From: [Nelson, Jennifer L \(DFW\)](#)
To: [Jeremiah Cromie](#)
Subject: RE: LP-22-00003 Haybrook Farms Ph 3 - Notice of Application
Date: Friday, August 5, 2022 3:18:17 PM

CDS is requesting comments on the following Long Plat Application: **LP-22-00003 Haybrook Farms Ph. 3**. Links to the file materials can be found below. I have attached the Notice of Application along

HAYBROOK FARMS PHASE 3
PART OF SECTION 30, T. 18 N., R. 19 E., W.M.
KITITAS COUNTY, WASHINGTON
- PRELIMINARY PLAT -

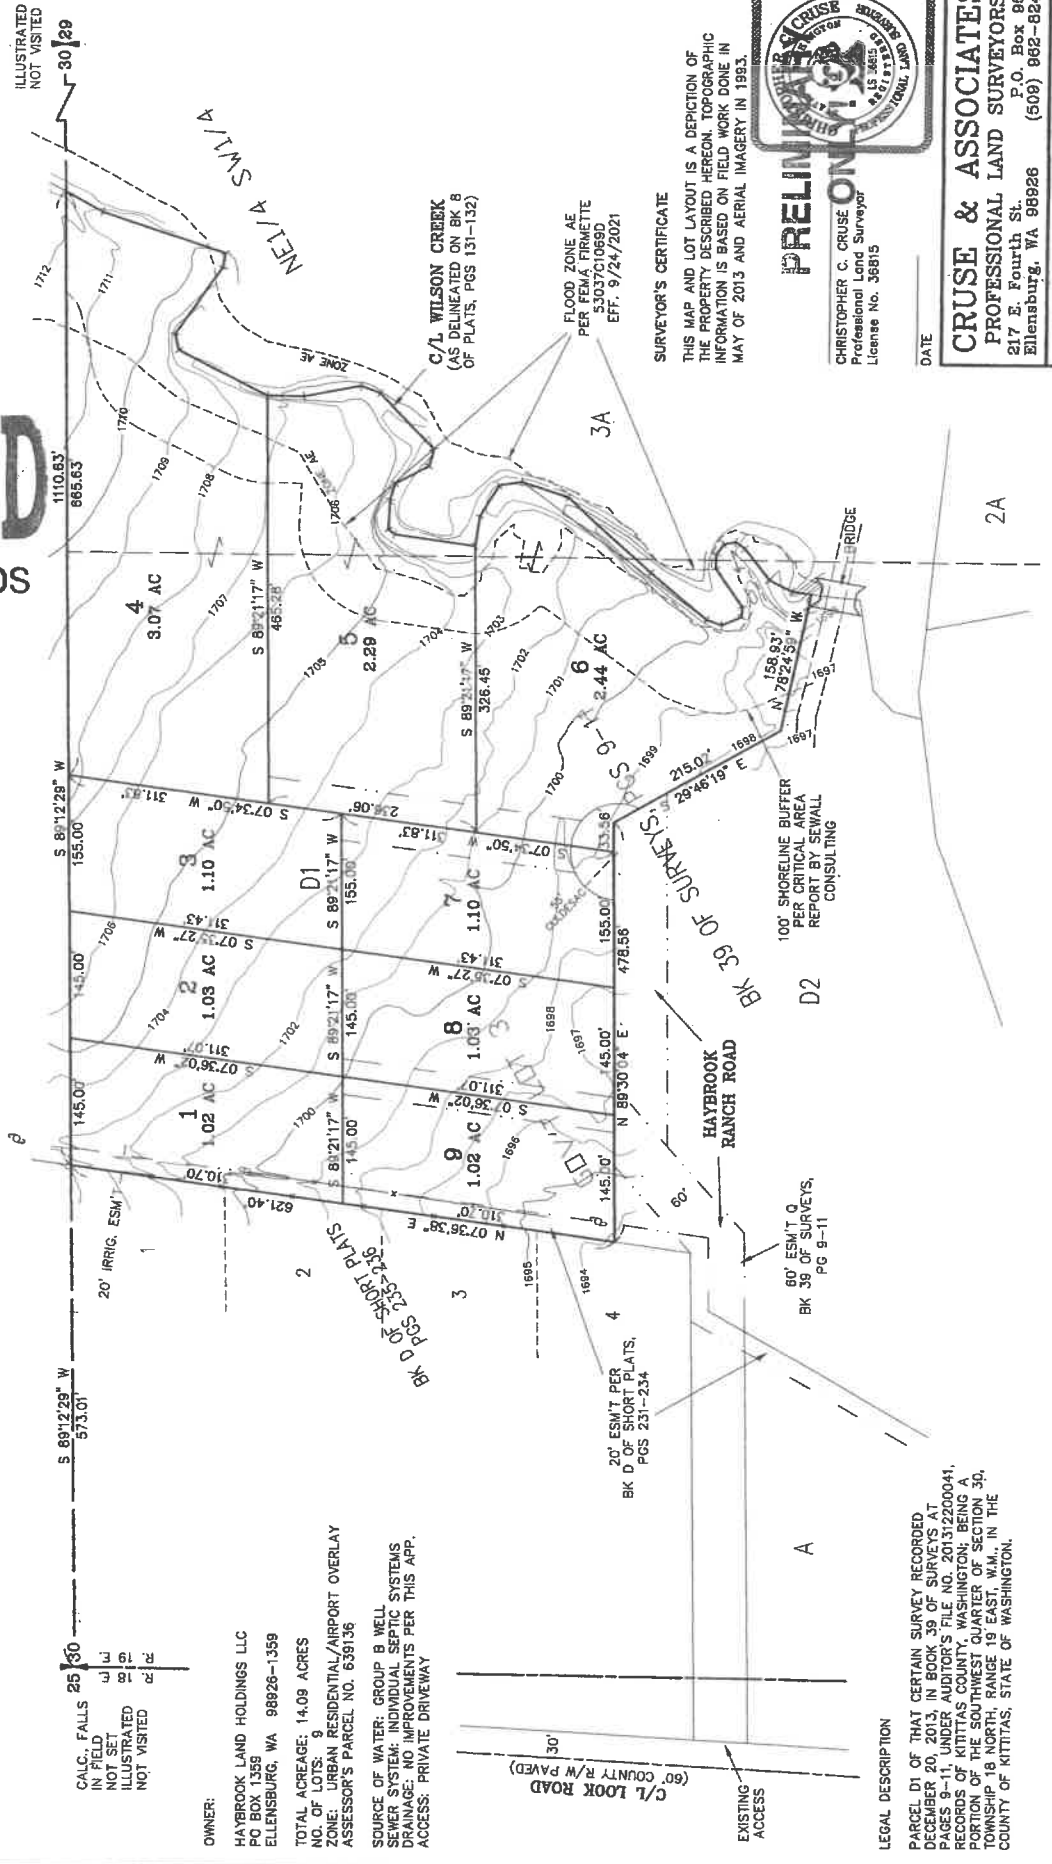
WDFW has reviewed the application materials and we appreciate the designation of Wilson Creek, the riparian management zone and the floodplain on the plat map. Wilson Creek is an important tributary to the Yakima River and it provides habitat for numerous species of native fish and wildlife. Technical and financial support is available to help landowners enhance the riparian habitat on their property and WDFW would be pleased to assist the landowners in this if they're interested.
